Application No. H09/0143/96

**REPLACEMENT DWELLING
RAVENSGATE
HOLBEACH ST JOHNS**

**REPLACEMENT DWELLING, RAVENSGATE, HOLBEACH ST JOHNS
FOR DR. R.W. & MRS H. THORPE.**

Amendment: Amend site area and re-position house
(drawing no. RWT.1A)

SITE PLAN
SCALE: 1/500

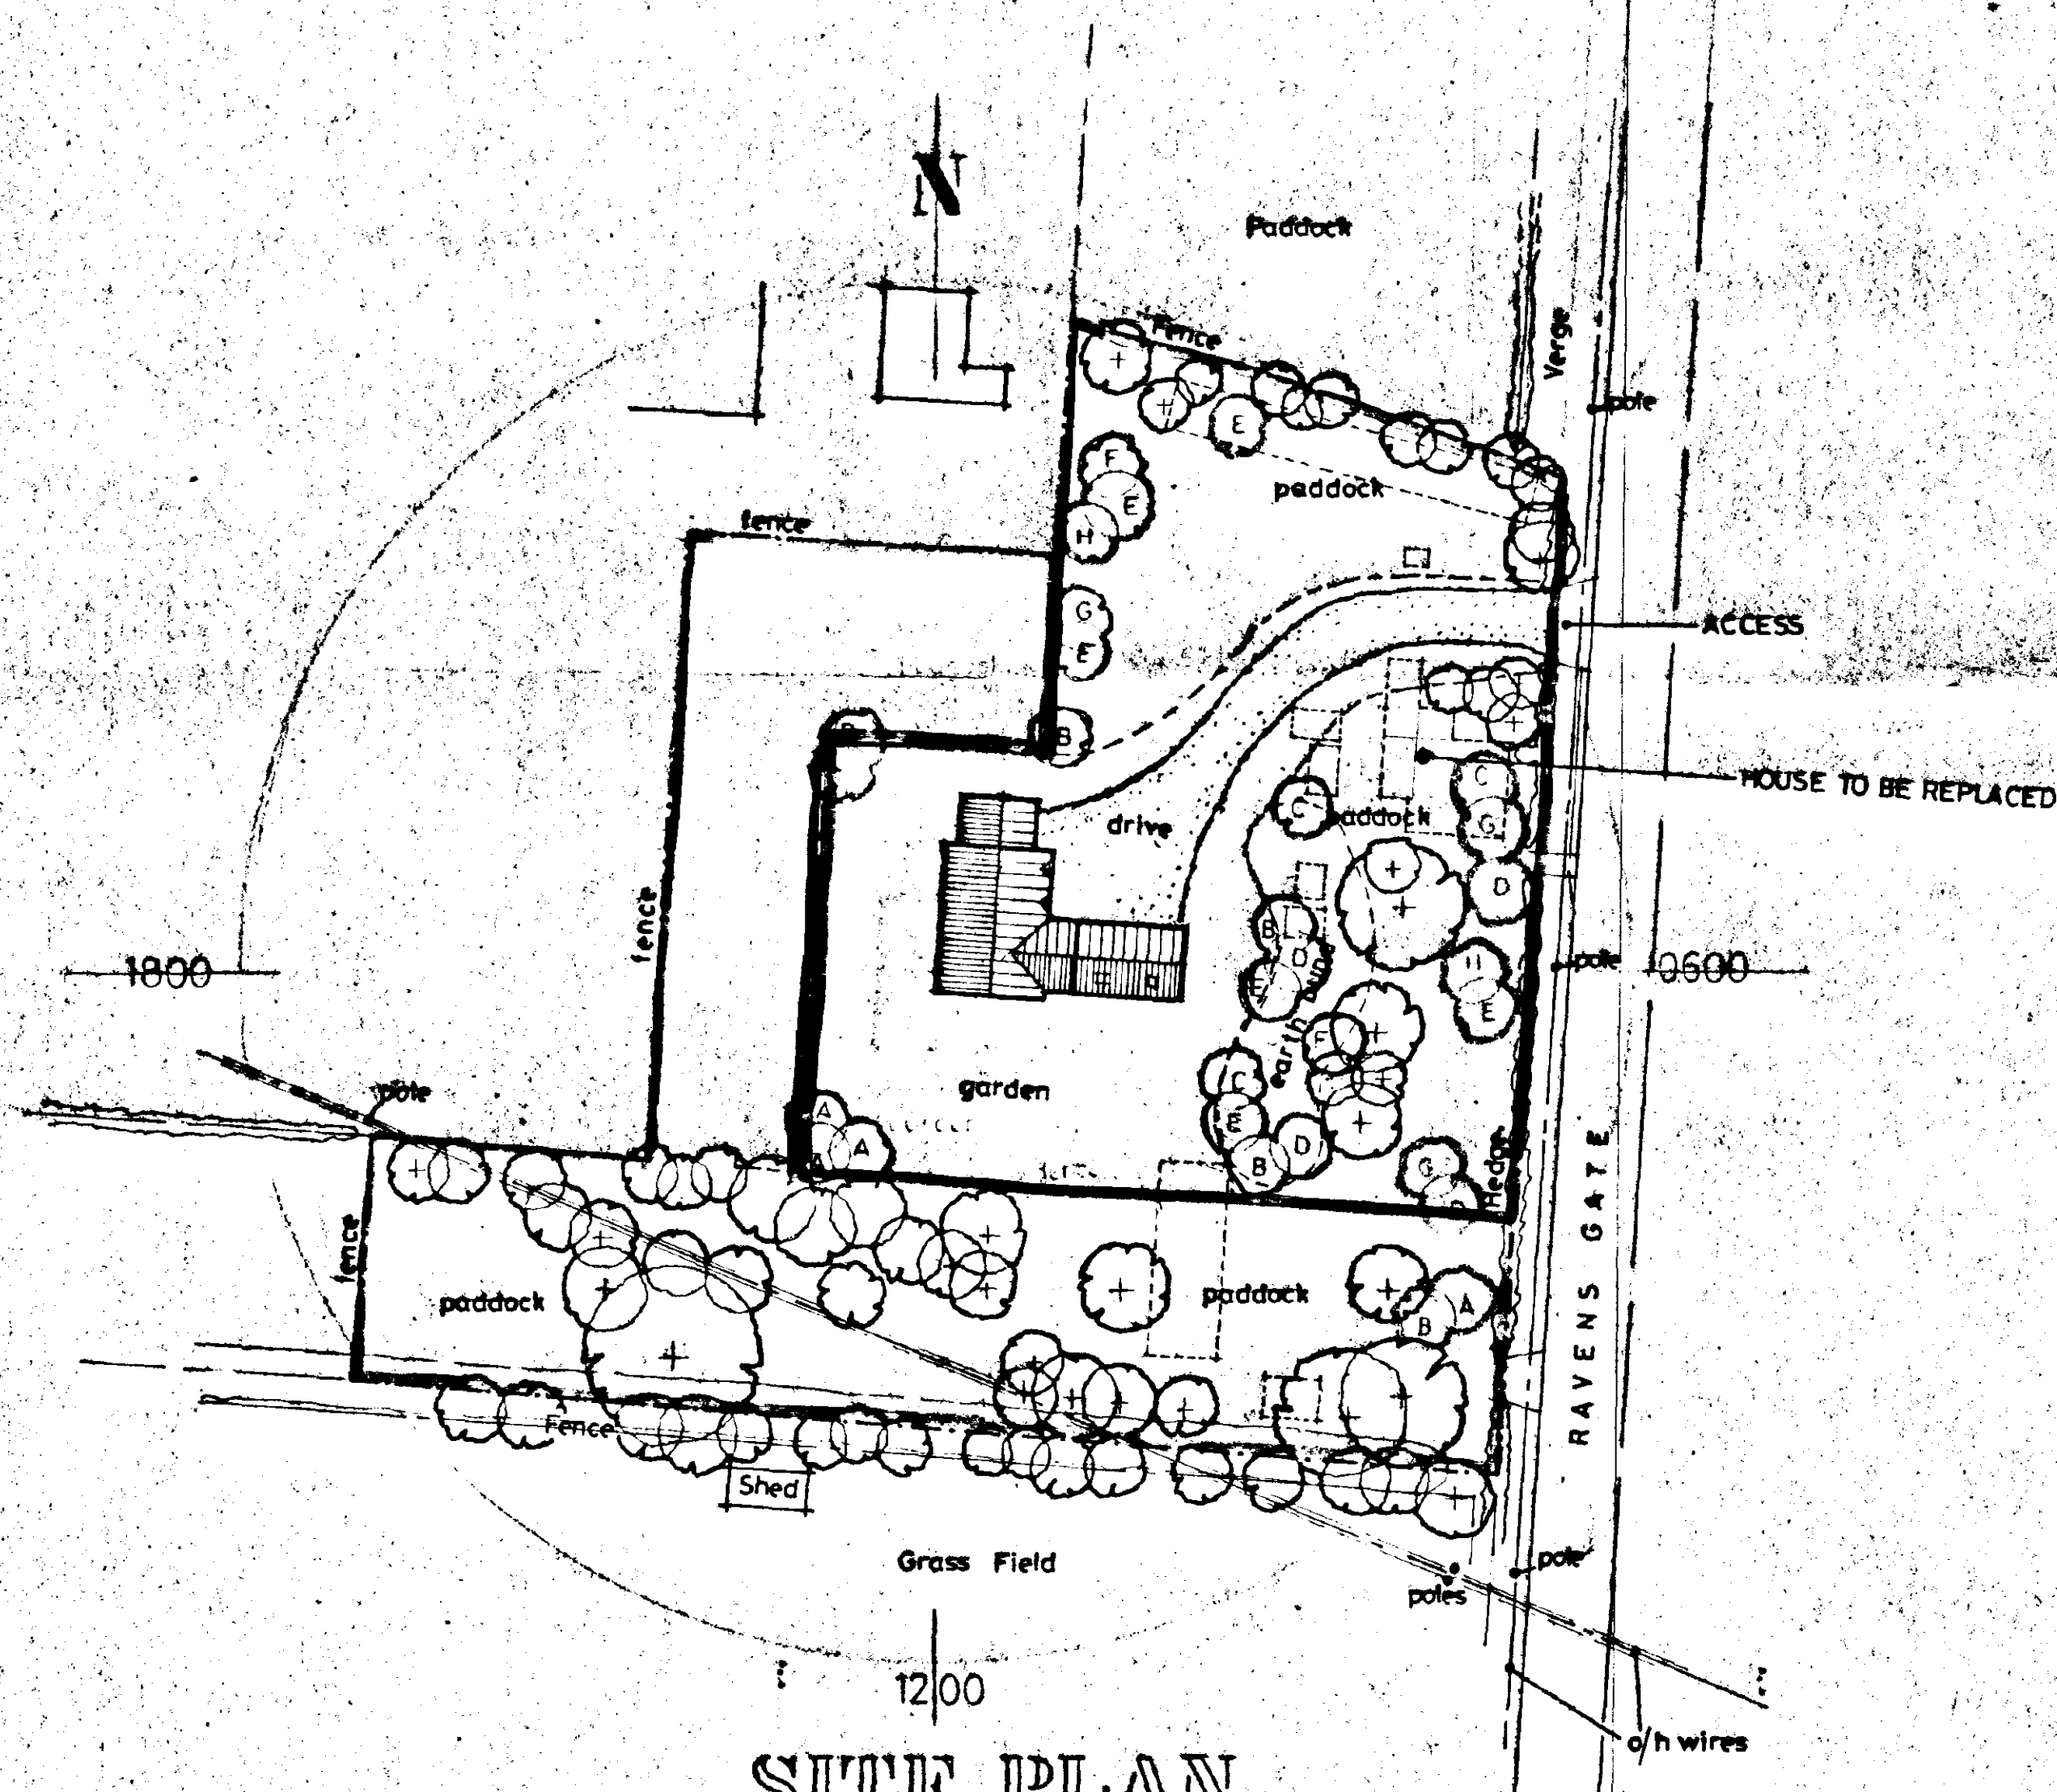
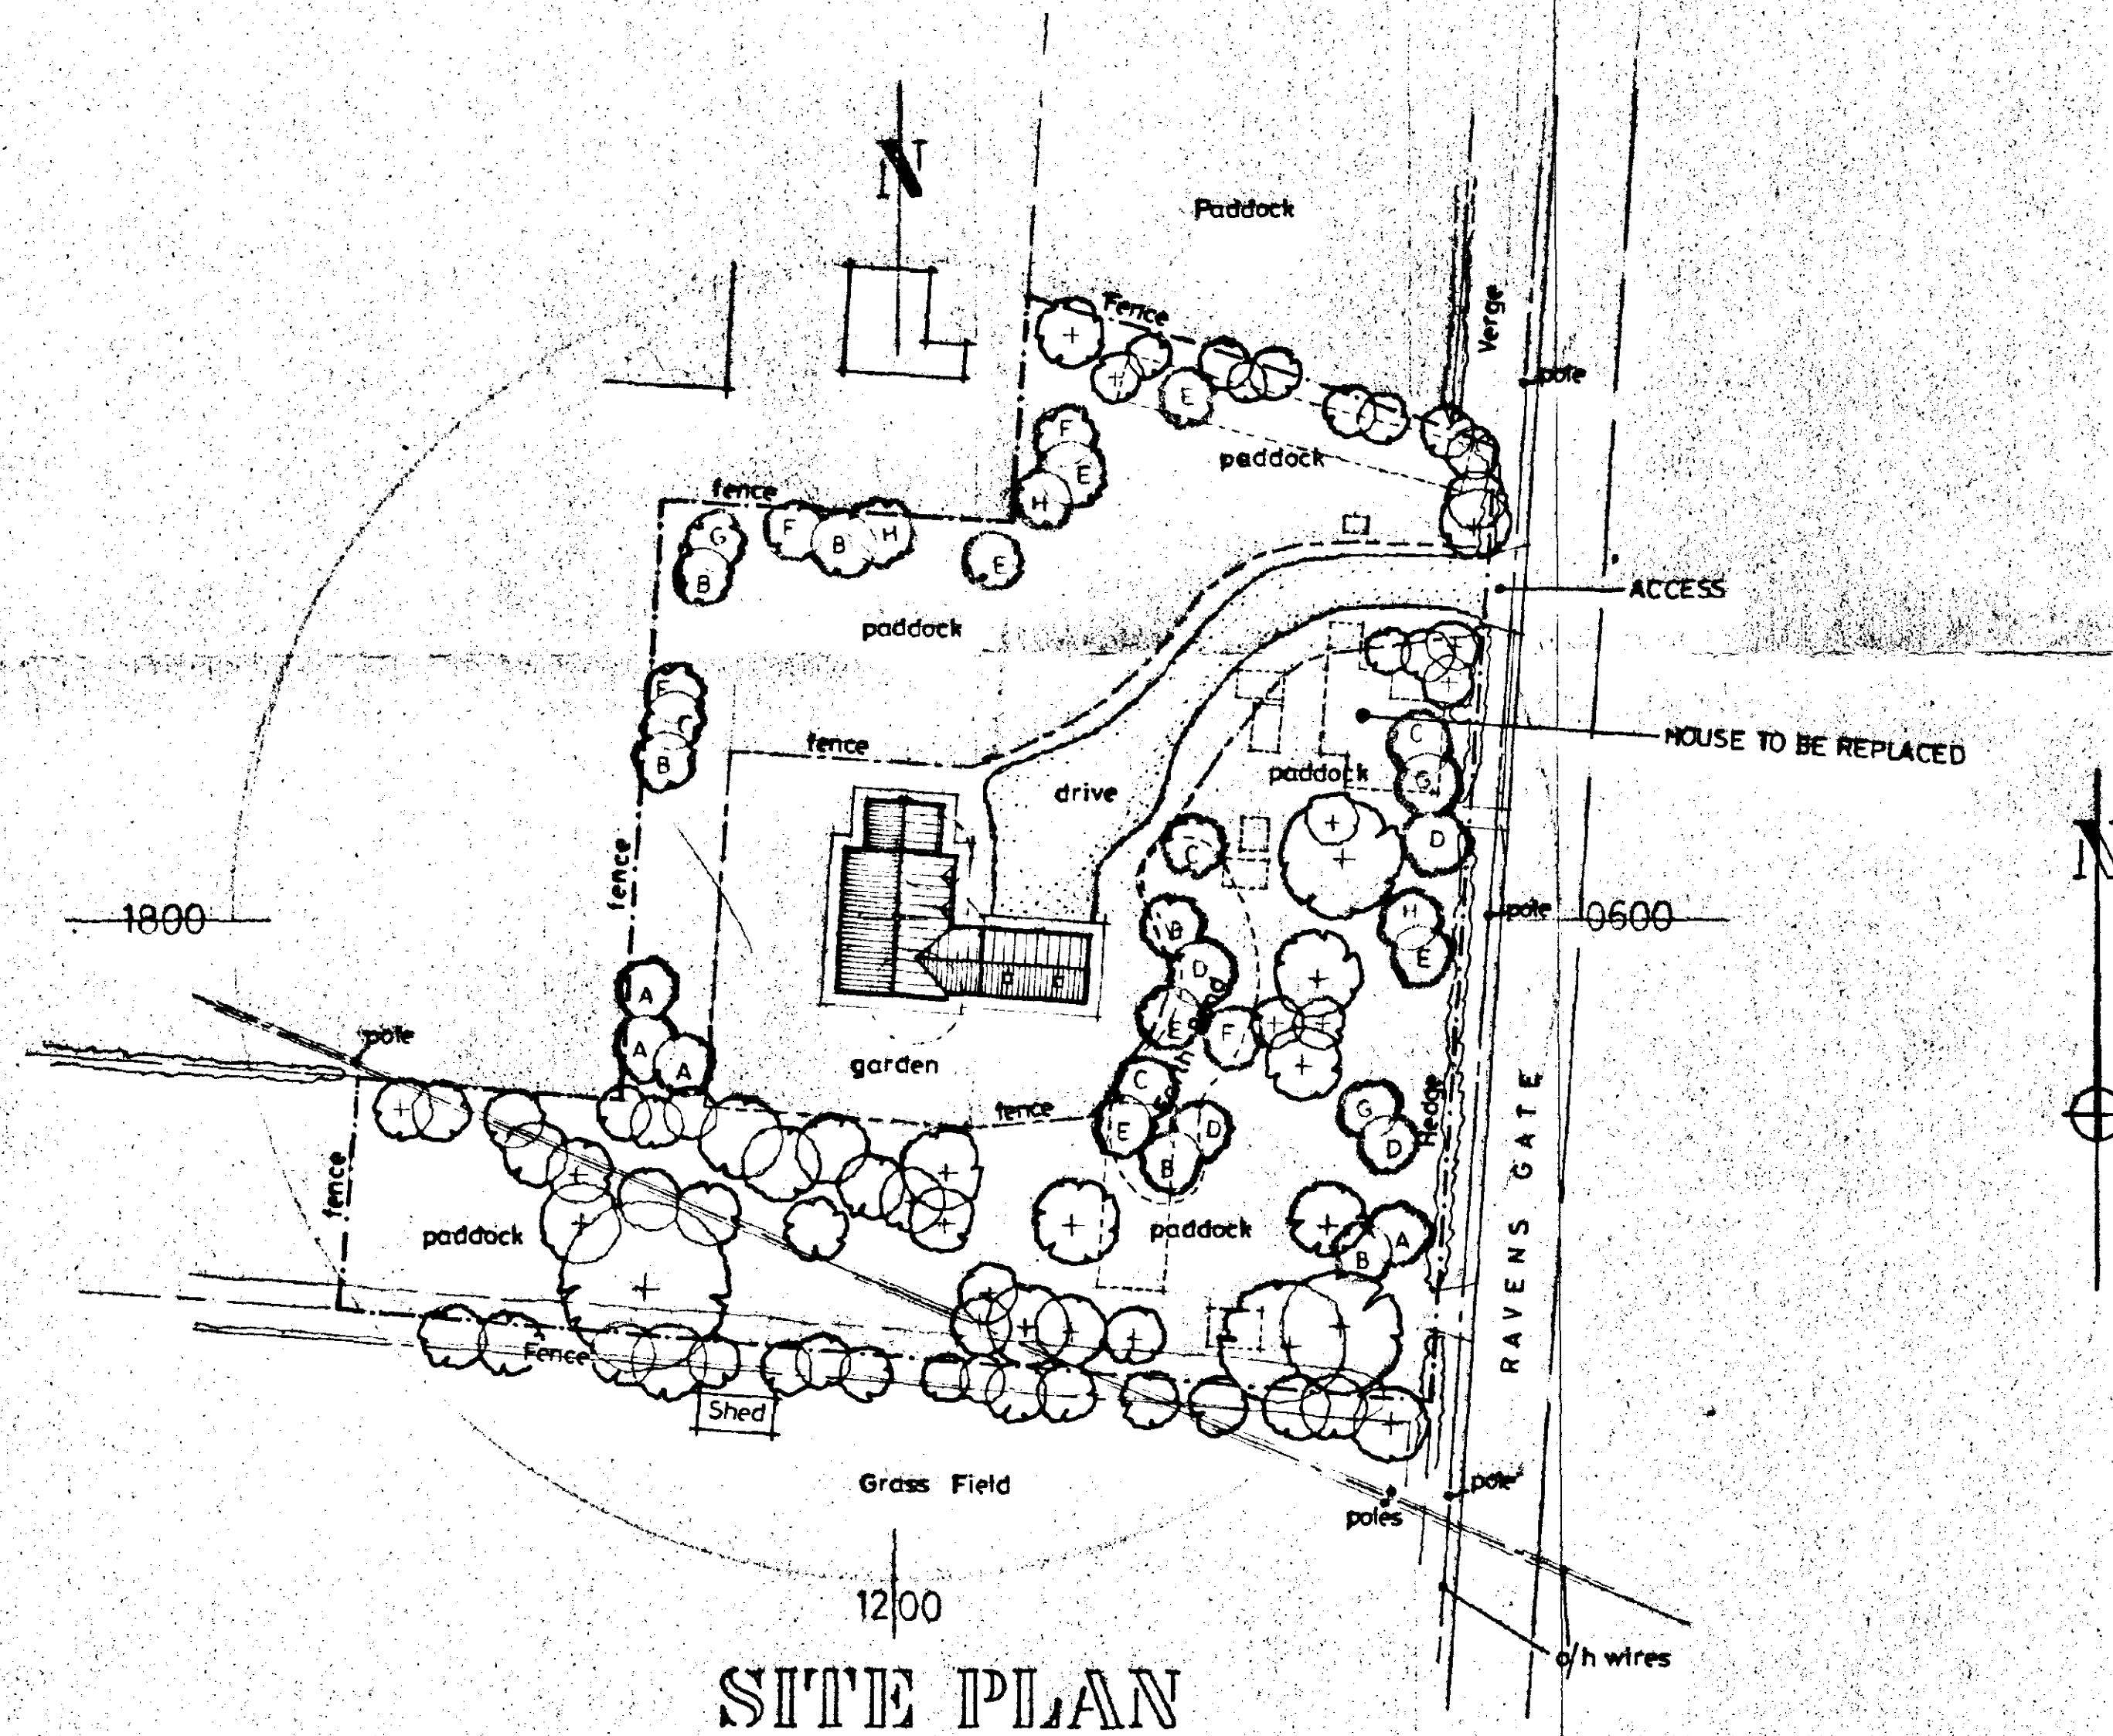
AMEND SITE AREA & RE-POSITION HOUSE.

1. Re-siting of the proposed dwelling to relate more favourably with the dwelling to be replaced.
2. Reduce the residential area of the application.
